**From:** Anita Gardner  
**Sent:** 25 June 2014 14:03  
**To:** Rosalind Bentley  
**Subject:** FW: Storage Barn, Hangleton Farm - F/58/14/PL (8059)  
**Attachments:** 8059-2B AS PROPOSED.pdf

**From:** Costers Chartered Surveyors [<mailto:design@costerassociates.co.uk>]  
**Sent:** 23 June 2014 12:38  
**To:** Anita Gardner  
**Subject:** Re: Storage Barn, Hangleton Farm - F/58/14/PL (8059)

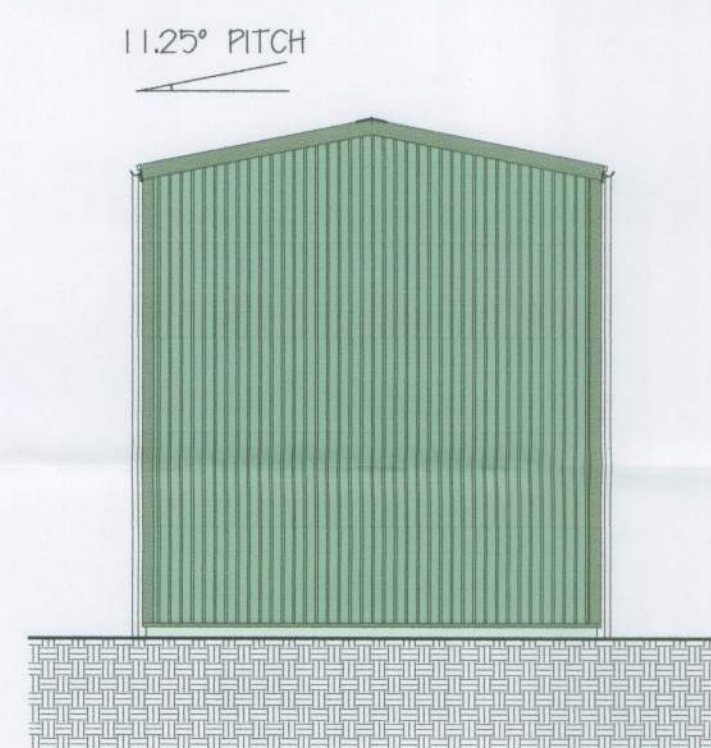
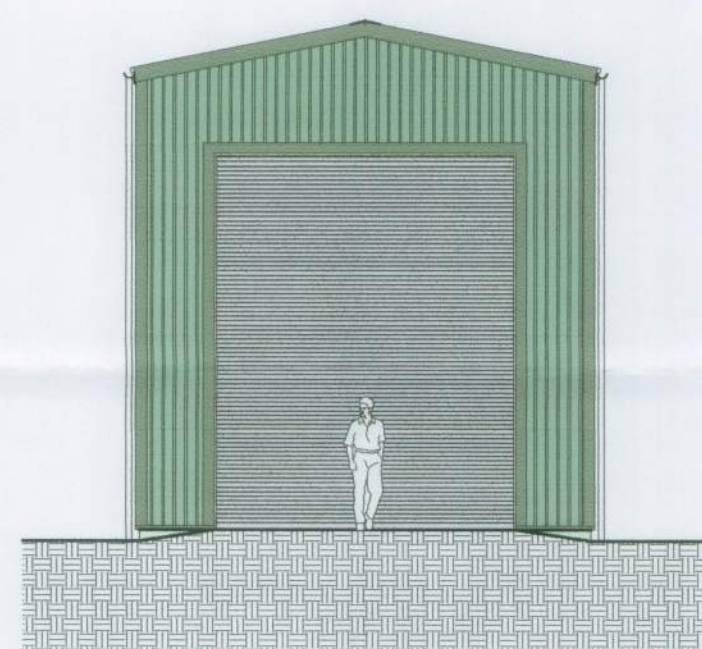
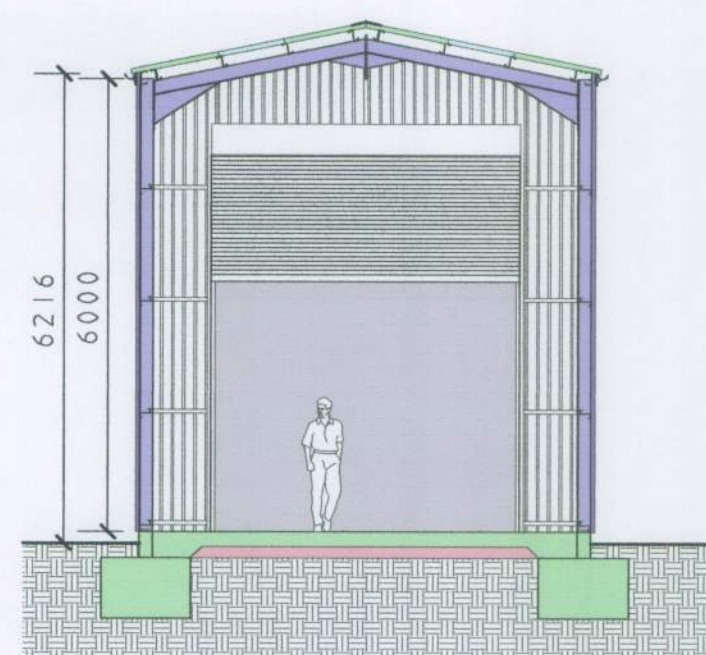
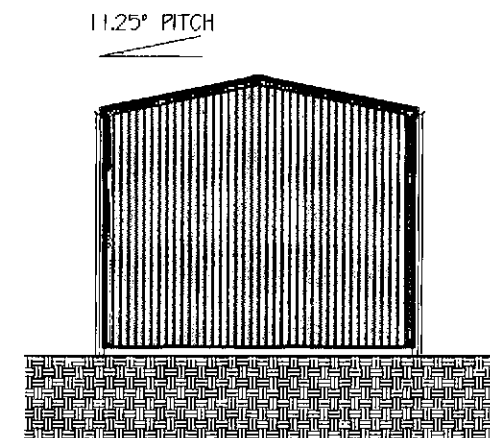
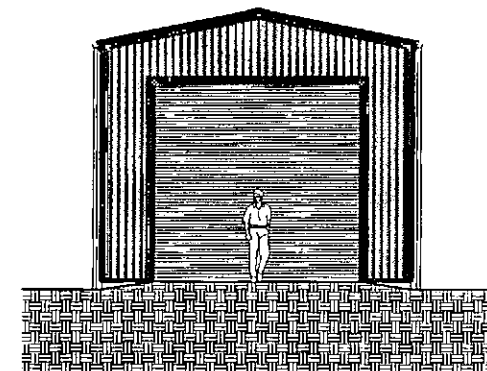
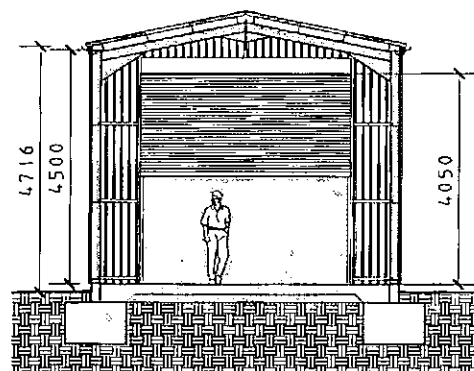
The prevailing bale size for purchase in larger quantities is 1.5 x 1.5 x 2.4 or 0.9 x 0.9 x 2.75 which to maximise delivery, quantities are required to be stacked to the fullest available height. In common with the majority of barns for hay/straw storage, eaves height is in the order of 6 Metres.

When viewed from the principle aspect of the centre, because of the building cluster the proposed height of the building would not be intrusive, however, my Client would be willing to reduce the height to 5 Metres - Revision B to our drawing No. 8059/2 attached.
